WEST SUSSEX COUNTY COUNCIL CONSULTATION

TO:	Arun District Council FAO: David Easton
FROM:	WSSC – Lead Local Flood Authority
DATE:	15 th March 2022
LOCATION:	Bognor Regis Golf Club Downview Road Felpham PO22 8JD
SUBJECT:	FP/274/21/OUT Outline planning application with all matters reserved, except means of access, for the erection of up to 480 new homes (C3), the formation of a new means of access onto Golf Links Road, together with the creation of new surface water drainage, new landscaping and habitat creation, ground works and other infrastructure and the retention and re-purposing of the retained club house (F2). This site also lies within the parish of Yapton, affects a Public Right of Way and is a Departure from the Development Plan. This application is subject to an Environmental Statement

Figure 7-1 - SuDS Location Plan

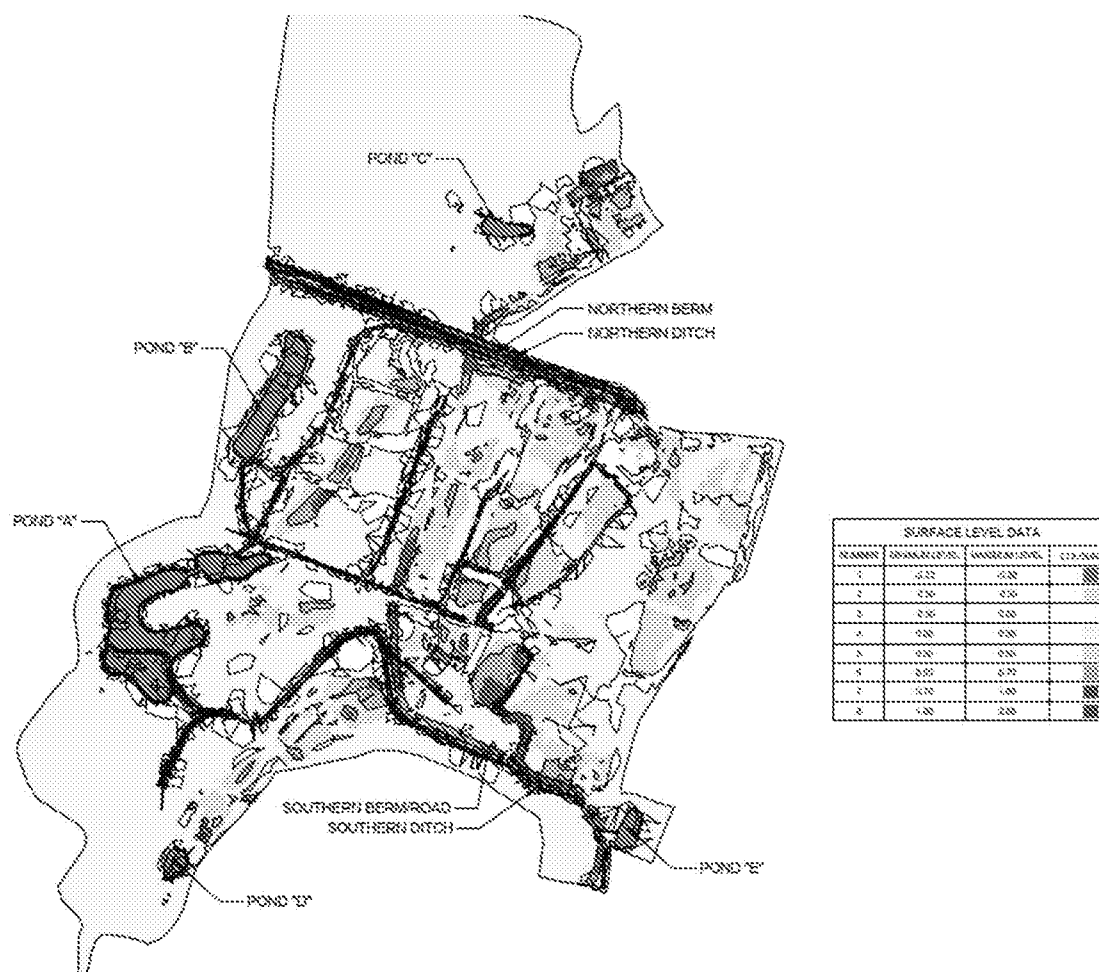
An FRA and Surface Water Drainage Statement have been provided but it is unclear how the surface water will be controlled from this development.

As per the District Drainage Engineers comments, further information is required to ensure the site can be suitably drained post development.
